City of Albuquerque
Stormwater Construction Site
Inspection Report

Project Name and Location	Sawmill Market 1901 Bellamah NW		
Site Contact Name & Agency	Lance Anderson Hart Construction	ESC File No. NPDES ID No.	013 D0174
Date of Inspection	12-18-18	Start/End Time	11:30/12:00
COA Inspector Name	Curtis Cherne, Stormwater Quality		
Describe Present Phase of Construction	Demo flat work

A1 EROSION AND SEDIMENT CONTROL PLAN
1" = 20'-0"

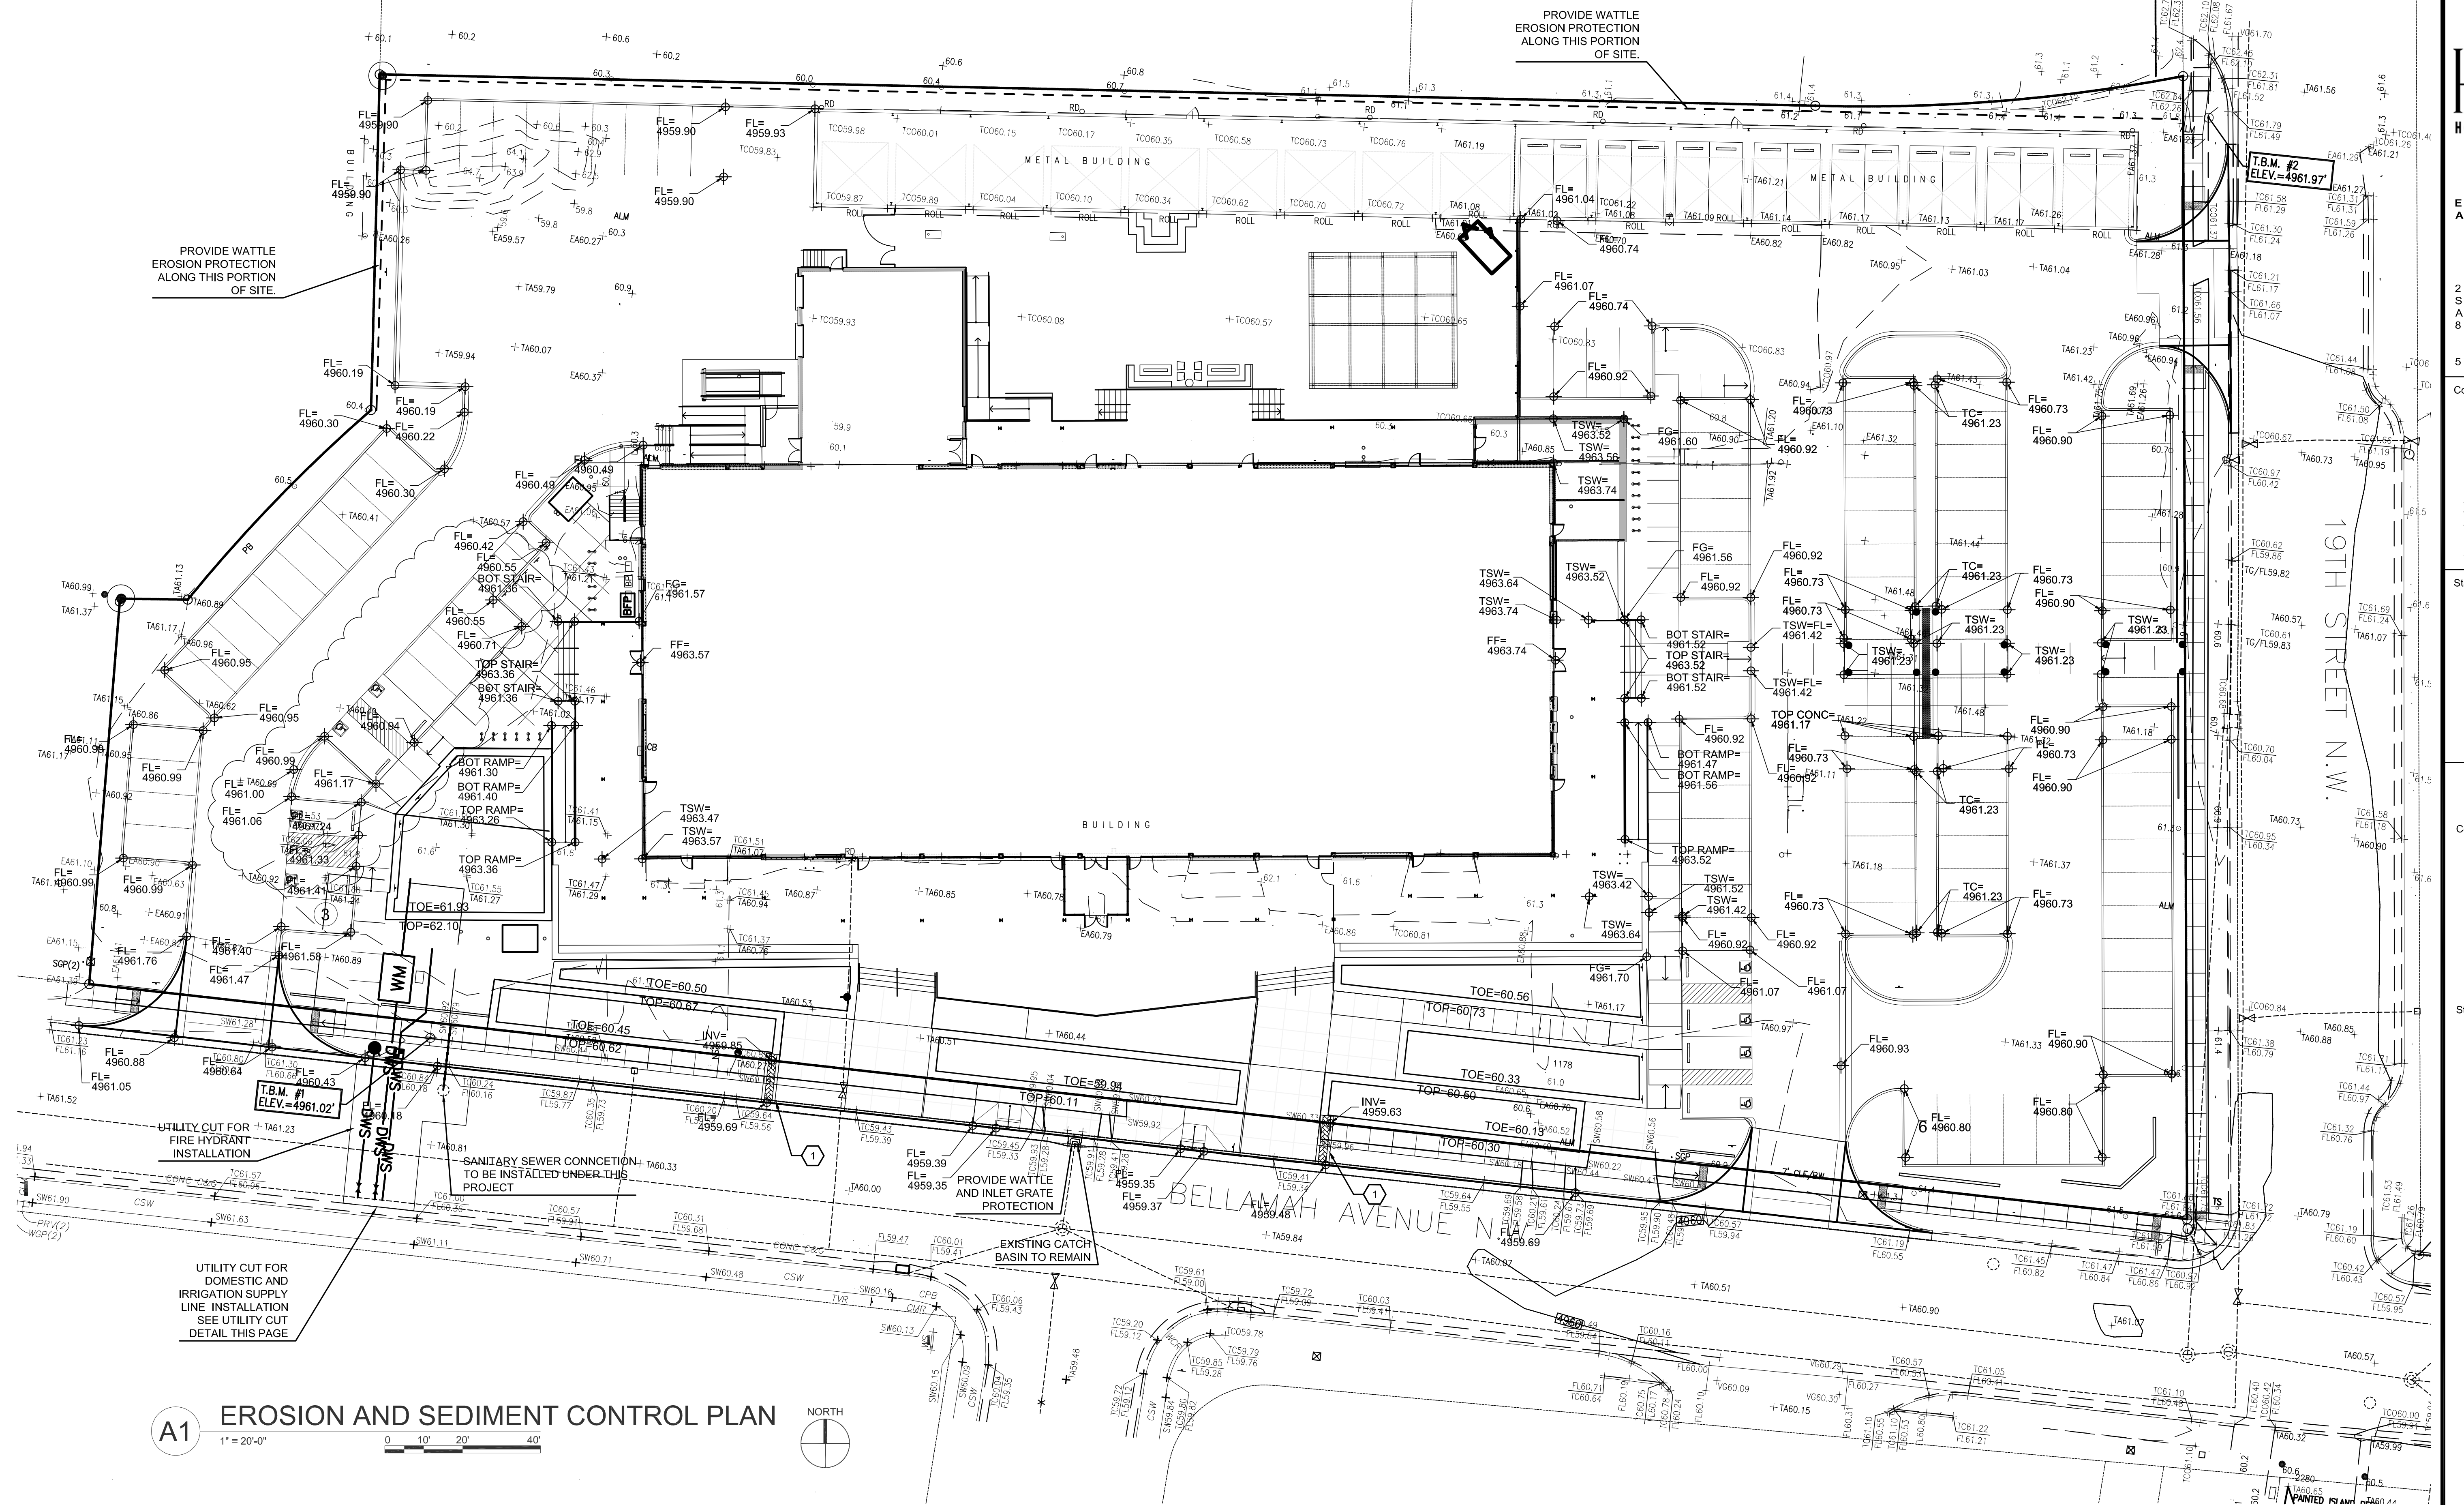
2.2.5	Manage stockpiles		
2.2.6	Minimize Dust		
2.2.10	Protect Storm Drain Inlets	✓	no inlet protection Bellanah
2.2.10	Protect Storm Drain Inlets		
2.2.11	Minimize erosion of conveyance channels
